Fire Marshal Division

**RE: Belleau Wood Brewing Company
6 W. Ivey St.
Lillington, NC 27546**

Application Number – FMFW1910-0005

TI-3.0

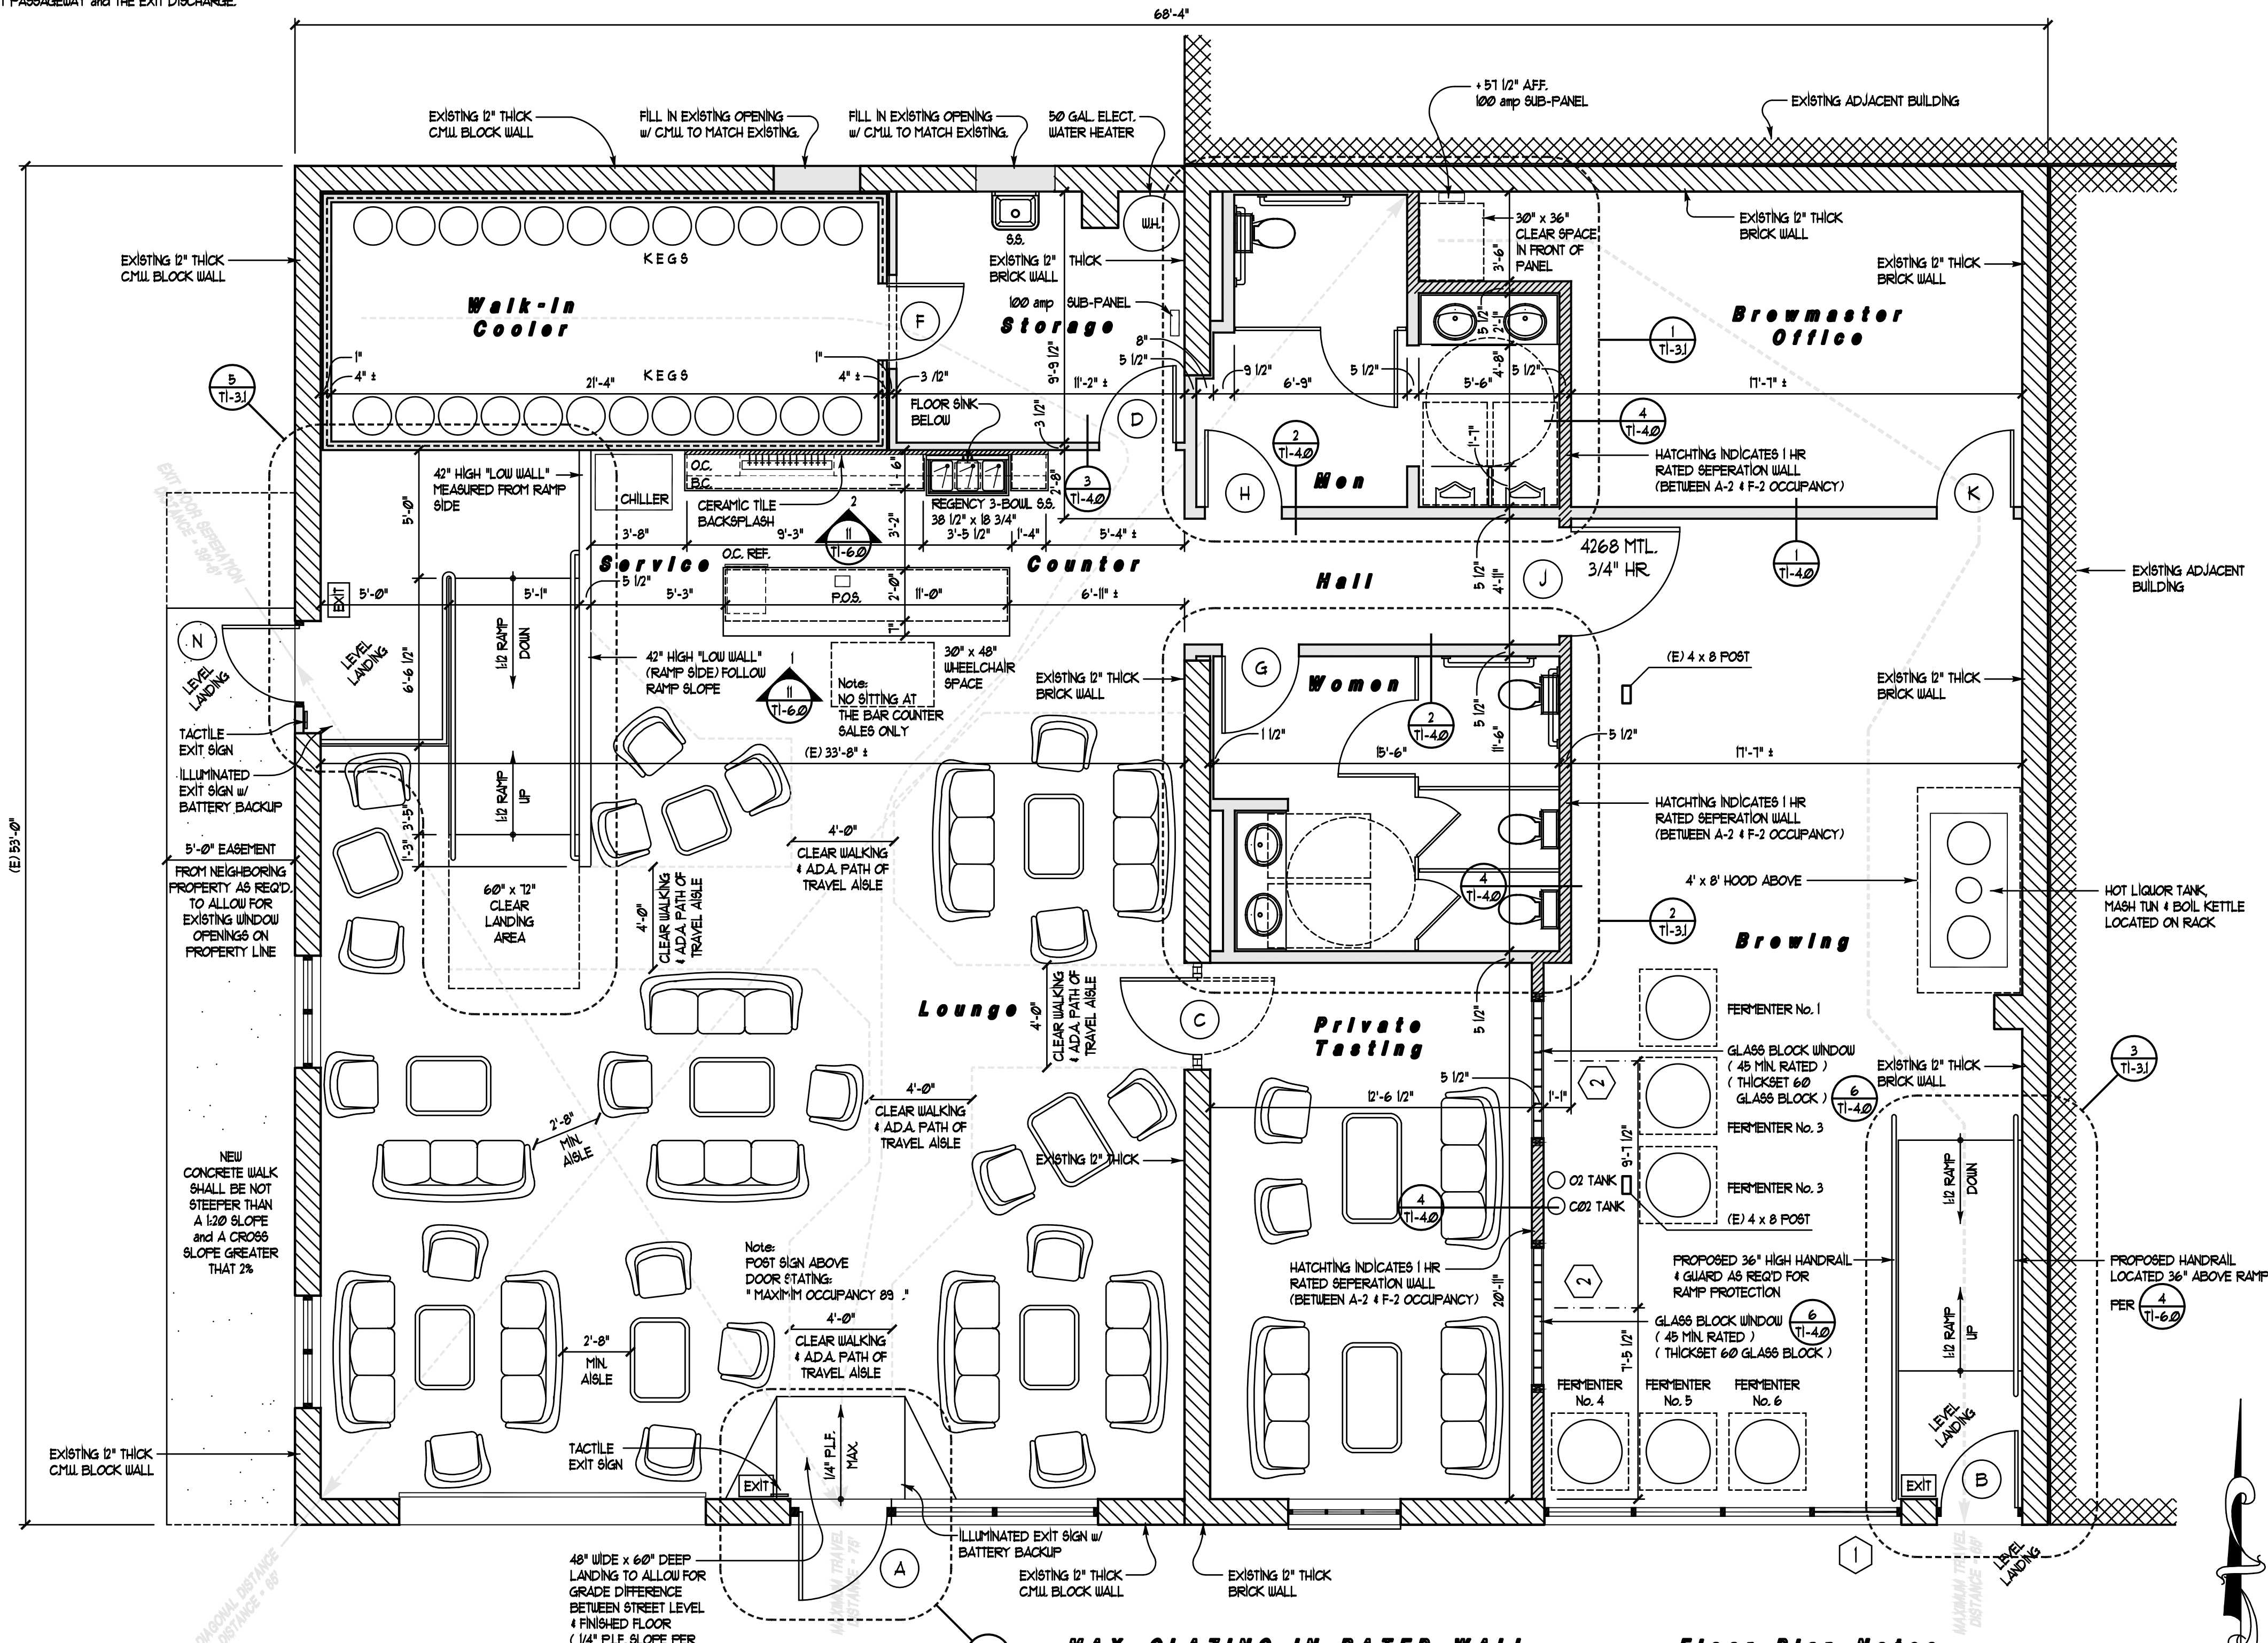
- **1010.1.10 Panic Hardware**
 - Building code summary indicted no panic hardware to be installed.
 - Panic hardware is required in a Group A occupancy with an occupancy load of 50 or more on all exit doors.
